**From:** Barrow Parish Council <barrowparishcouncil@gmail.com>  
**Sent:** 06 February 2019 22:14  
**To:** planning  
**Subject:** FAO Robert Major: Consultation on planning application 3/2019/0012 land SW and W of Whalley Road, Barrow, BB7 9XW  
**Attachments:** 19 0012 Consult.pdf  
**Follow Up Flag:** Follow up  
**Flag Status:** Flagged

Consultation on planning application 3/2019/0012 land SW and W of Whalley Road, Barrow, BB7 9XW

Barrow Parish Council has reviewed the proposals for layout, scale and appearance of this residential development of 233 dwellings and associated works. Whilst the parish council strongly objects to the addition of more houses in Barrow, it accepts that a development on this site received planning consent on appeal in 2014 and the housing numbers are included in the Core Strategy.

Street Scene 1

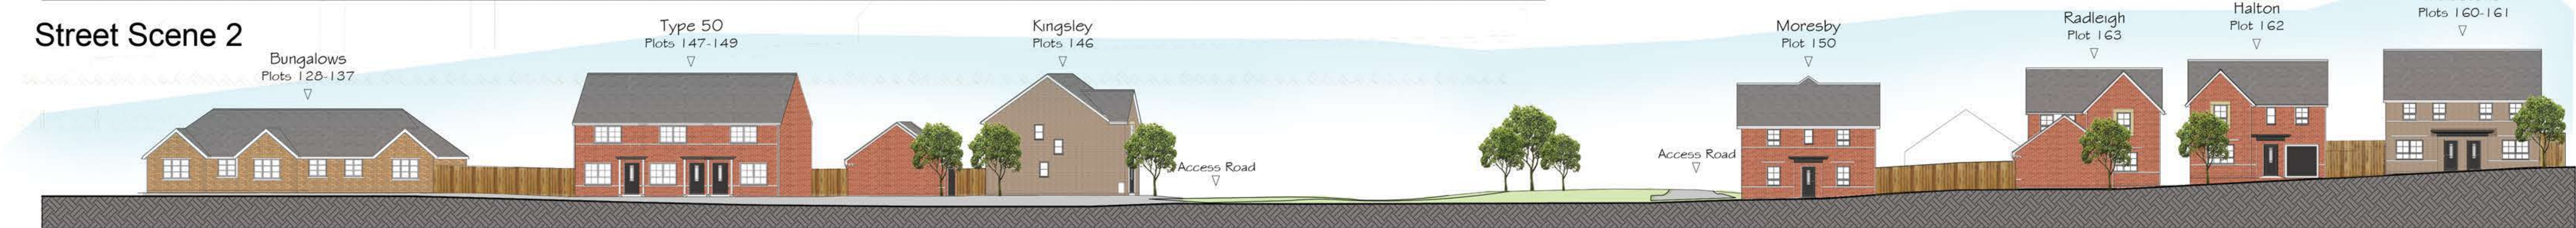
4. The plans show three storey houses fronting onto Whalley Road (eg type Braxton). It is felt that having three storey houses fronting onto the main road through Barrow would be detrimental to the street scene and affect the residential amenity of the homes on the opposite side of Whalley Road. It is hoped that these can be changed to two storey houses to reduce the development's impact on the village.
